KITTITAS COUNTY COMMUNITY DEVELOPMENT SERVICES

RE: Early Dawn Short Plat (SP-08-00014)

The Kittitas County Community Development Services Department has determined that the Early Dawn Short Plat (SP-08-00014) is a complete application and hereby grants **conditional preliminary approval** subject to the following conditions:

EARLY DAWN SHORT PLAT
 PART OF SECTION 2,
 T. 16 N., R. 19 E., W.M.,
 KITTITAS COUNTY, WA

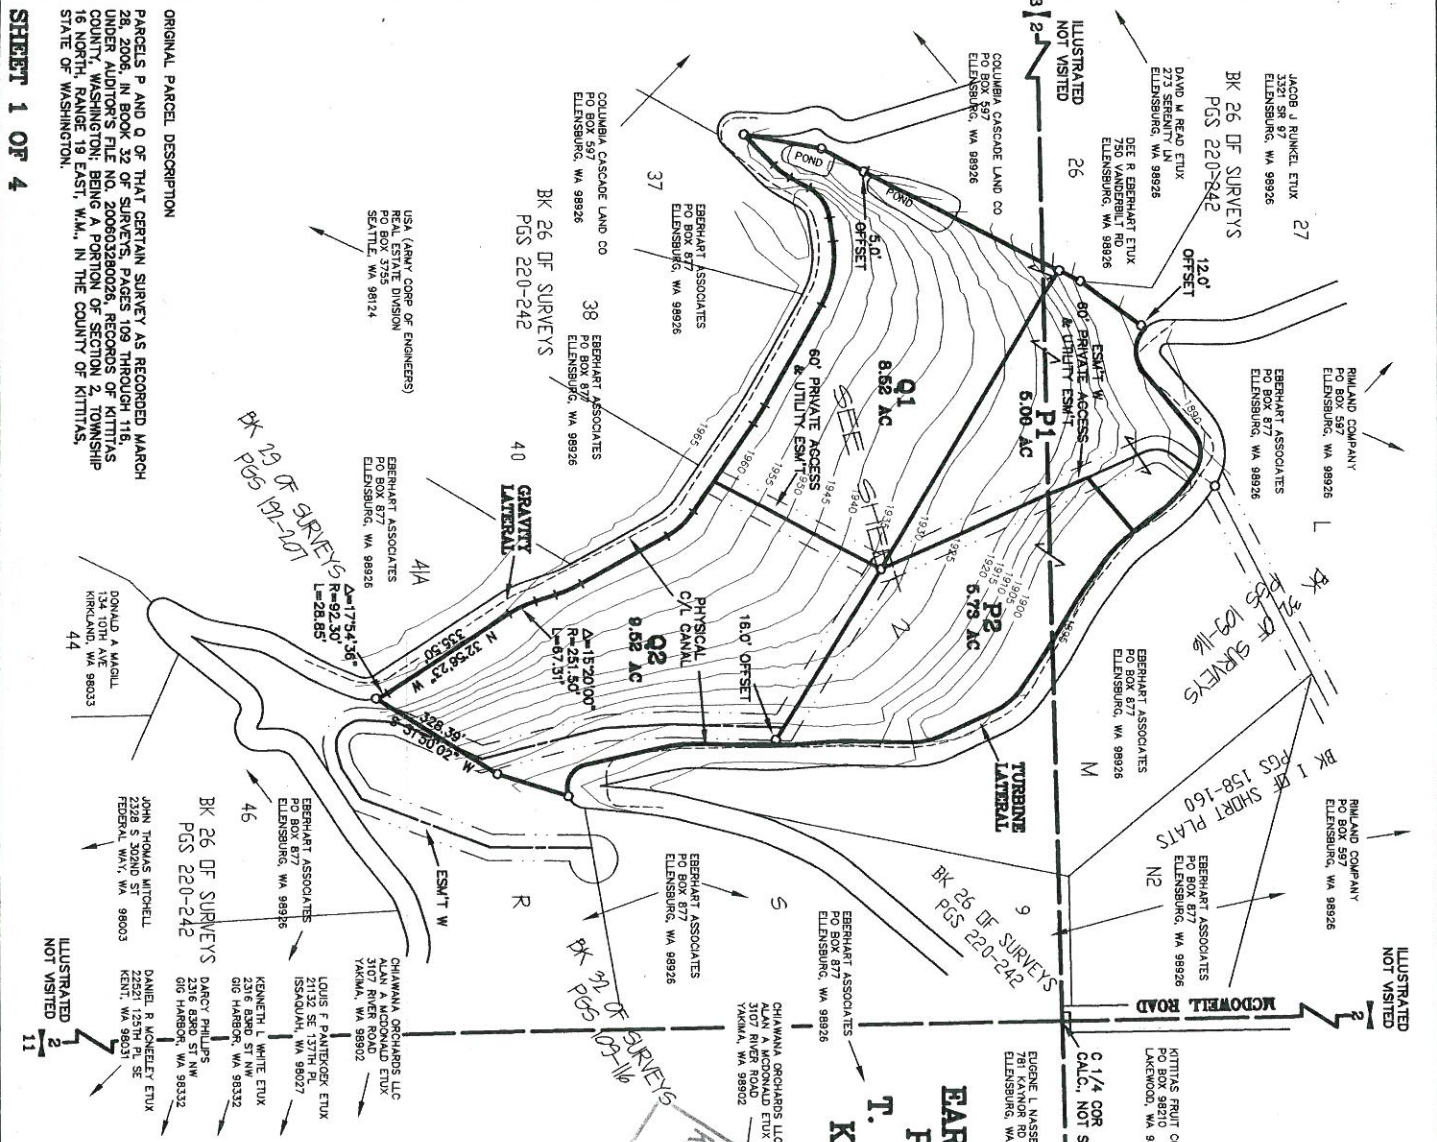
2. Private Road Improvements Easement "W": The proposed access off McDowell Road shall meet or exceed the low density road requirements as shown below. Any further subdivision or lots to be served by proposed access may result in further access requirements.
 - a. Access easement shall be a minimum of 60'. The roadway width shall be a minimum of 20', with 1' shoulders = 22' total width.
 - b. All easements shall provide for AASHTO radius at the intersection with a county road.
 - c. Minimum centerline radius will be 60'.

- d. Surface requirement is 6" gravel surface.
 - e. Maximum grade is 8% flat, 12% for rolling or mountainous.
 - f. Stopping site distance, reference AASHTO.

- g. Entering site distance, reference AASHTO.
 - h. Maintenance of driveway approaches shall be the responsibility of the owner whose property they serve. The County will not maintain accesses.

- i. Any further subdivision or lots to be served by proposed access may result in further access requirements. See Kittitas County Road Standards.
 - j. A paved apron shall be constructed at the intersection of the existing private road and the intersection of the County road right of way.

5. Turbine Lateral Crossing: It appears that Access Easement "W" crosses the Kittitas Reclamation District's turbine lateral. The applicant shall contact the Kittitas Reclamation District regarding any additional requirements they may have.
